PLANNING CONSULTATION RESPONSE

Application No	2025/1071
Proposal	Erection of 9 Detached Dwellings
Address	Alexandra Working Mens Club, 59 High Street, Royston, Barnsley, S71 4RF
Date of Consultation Reply	02/03/26
Consultee	Highways Development Control

Proposed Frontage Detail Plan
Scale 1:100

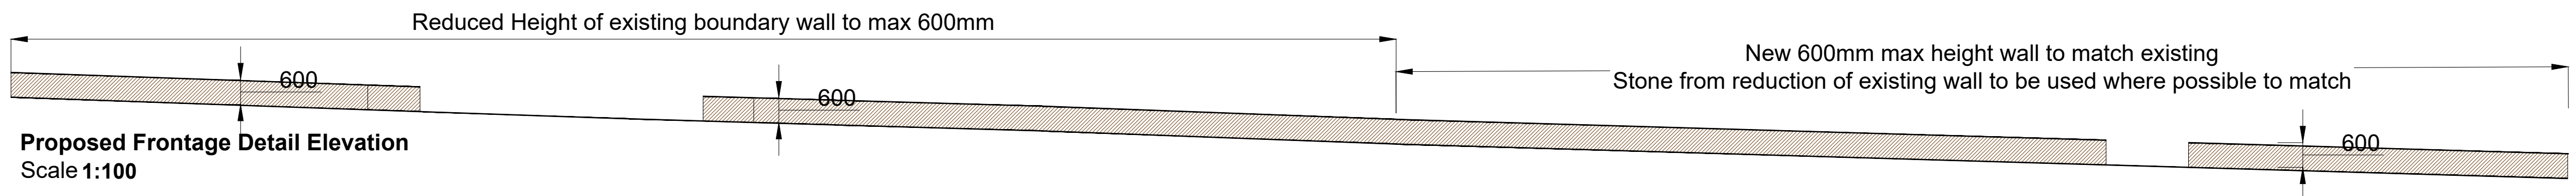
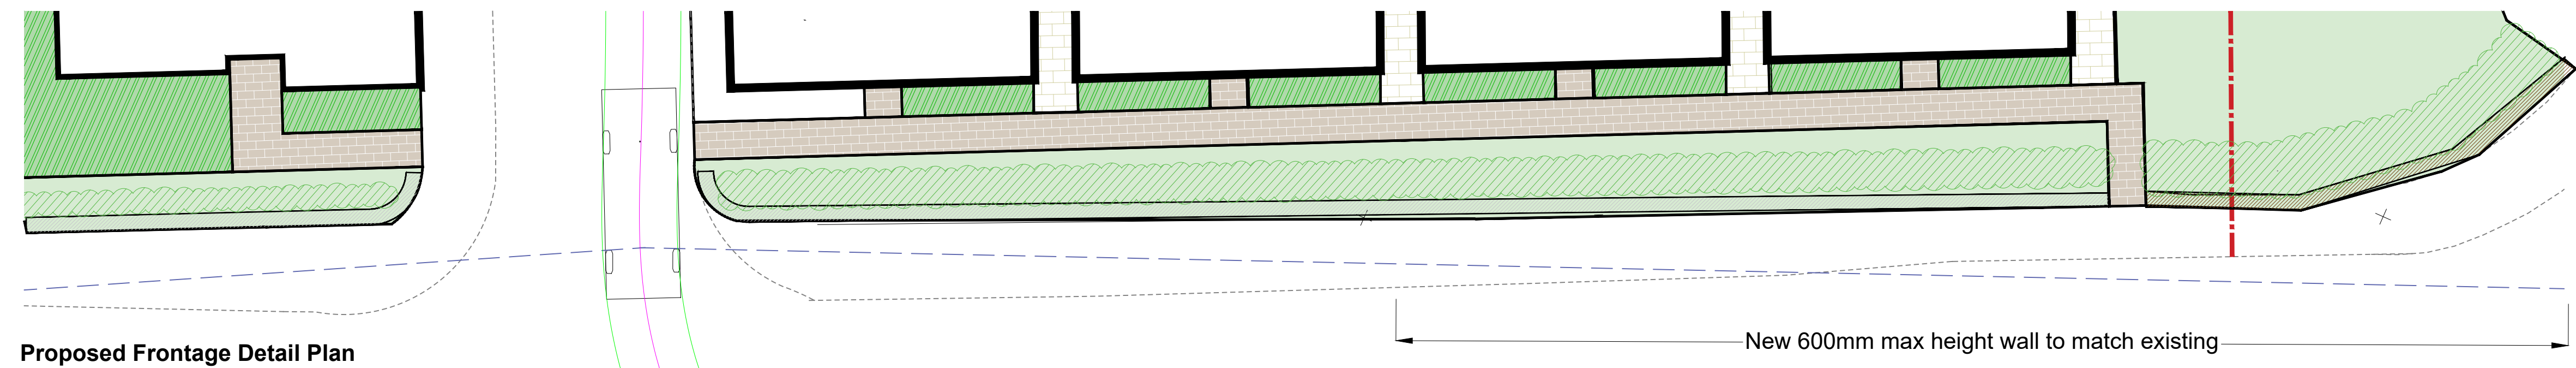
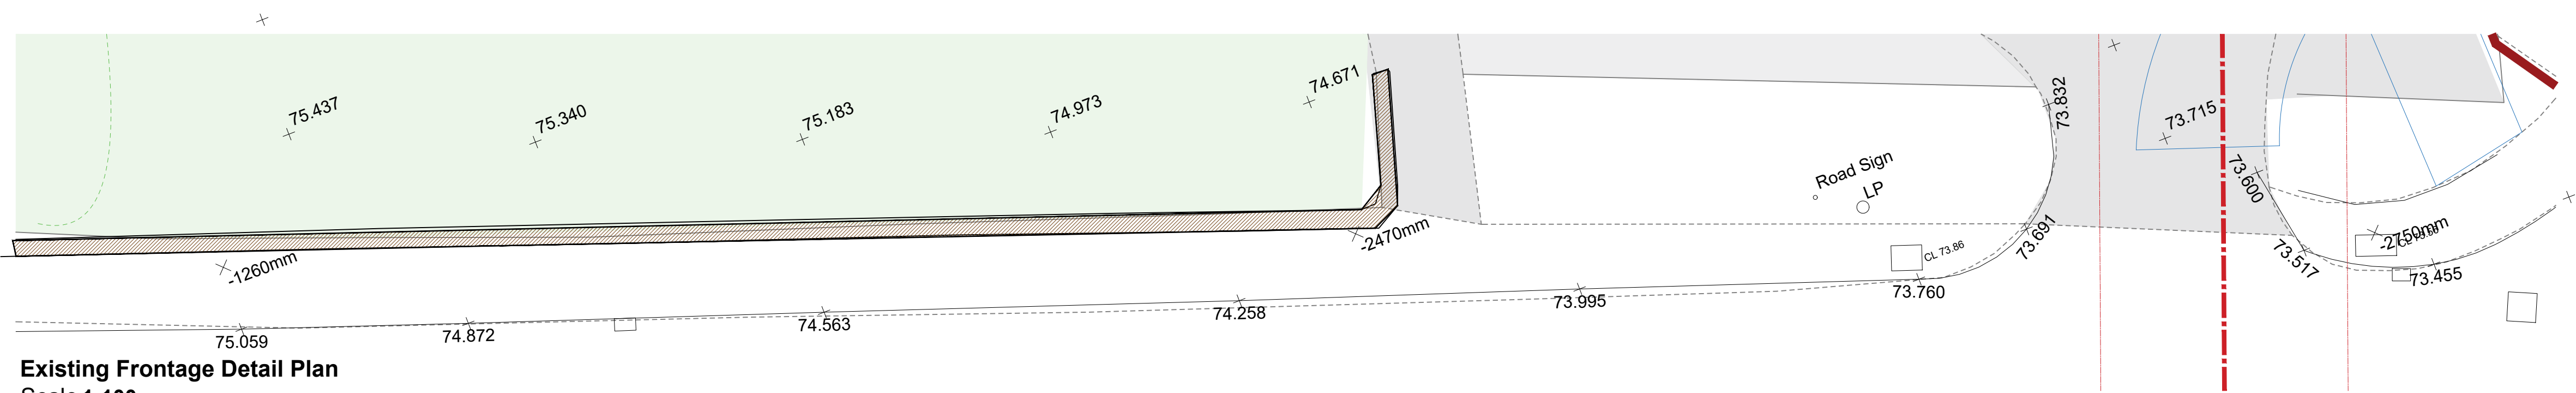
The submitted layout indicates that several of the proposed dwellings would be served via individual private driveways taken directly from High Street. This arrangement would introduce a number of separate vehicular access points along the site frontage onto a classified road (B6428). The intensification of access points along a classified road is not considered good highway design practice and conflicts with the principles set out within the South Yorkshire Residential Design Guide, which seek to minimise the number of direct vehicular accesses onto the public highway where possible.

The proposed arrangement would result in a series of closely spaced vehicle crossing points along the frontage of the site, increasing the potential for conflict between vehicles entering and leaving the development and pedestrians travelling along the adjacent footway. This approach also conflicts with the street design hierarchy set out within Manual for Streets,

which prioritises pedestrian movement and seeks to avoid unnecessary vehicle crossings of footways where these can introduce additional conflict between vehicles and pedestrians.

In addition, the proposed driveway arrangements are likely to result in larger, delivery vehicles reversing onto or off High Street, which is unacceptable on a classified road.

Whilst it is acknowledged that an existing vehicular access currently serves the site from High Street in close proximity to the junction with Hallcroft Rise, the proposed layout would introduce several additional access points along the site frontage. From a highways perspective it would be more appropriate for the development to be served via a single consolidated access point, potentially relocating the existing access in a manner that provides an appropriate separation distance from the junction with Hallcroft Rise. A shared internal access serving the development would reduce the number of vehicular crossing points onto High Street and provide a safer and more coherent arrangement in accordance with the principles of the South Yorkshire Residential Design Guide. It should be noted that rather than several shared private drives, for developments exceeding 5 dwellings, an adoptable layout would be preferable.

Given the concerns outlined above regarding the proliferation of individual vehicular accesses onto High Street and the potential for reversing manoeuvres onto a classified road, the Local Highway Authority cannot support the proposed layout in its current form. The access arrangements should therefore be reconsidered to provide a more consolidated access solution that better accords with the principles of the South Yorkshire Residential Design Guide and provides a safer relationship between the development and the public highway.
